Submission to Section 4.55(2) Modification.
Fort Street Public School FSPS (SSD 10340)
By Fort Street Public School Parents & Citizens Association (P&C)
20 May 2021

*Proposed Phase 1 Pick-up/Drop-Off Arrangement*

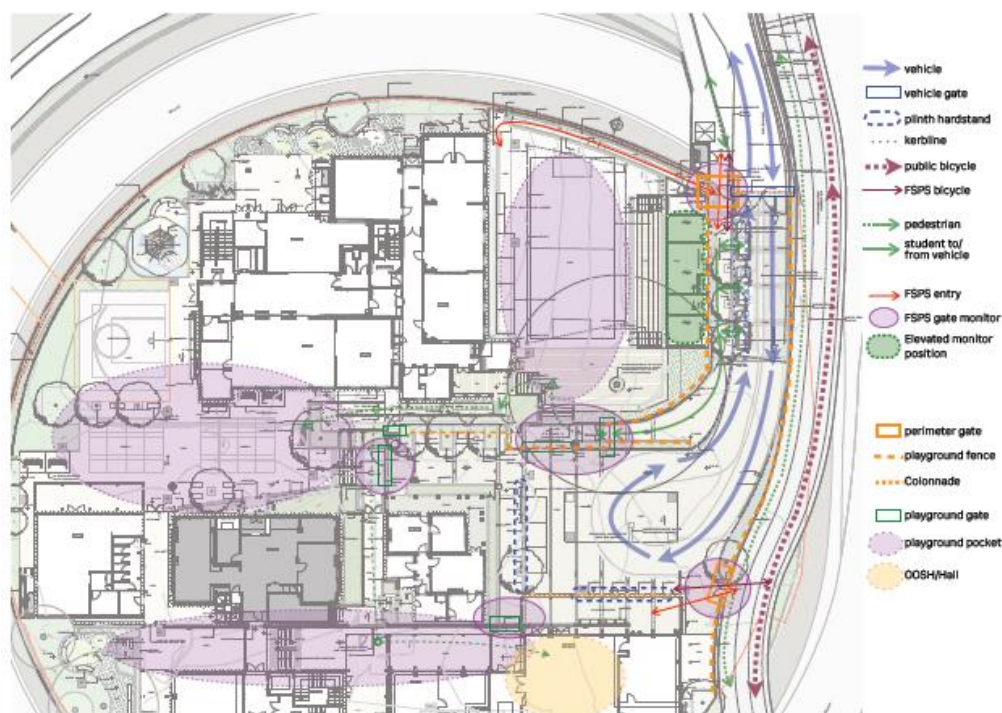
- It is imperative then, that Phase 1 operations be safe. However, in Phase 1, a pedestrian crossing is proposed on Upper Fort Street, just outside the new school gates at the entrance to the Cycleway. We are concerned that the congregation of cars, pedestrians and cyclists in one focal point, could result in unfortunate accidents.

- Cyclists are still crossing a line of cars moving in the drop off / pick up queue on Upper Fort Street, to get on to the Cycleway. The Modification document is silent on how this potential conflict will be managed.

- The P&C unreservedly supports the position of the school principal and staff.
- The P&C calls for an alternative drop off and pick up process, where cyclists can be segregated completely from and not cross vehicular traffic or alternatively, dismount whilst on school land and compelled to walk with their bicycles to re-join the Cycleway outside school land.
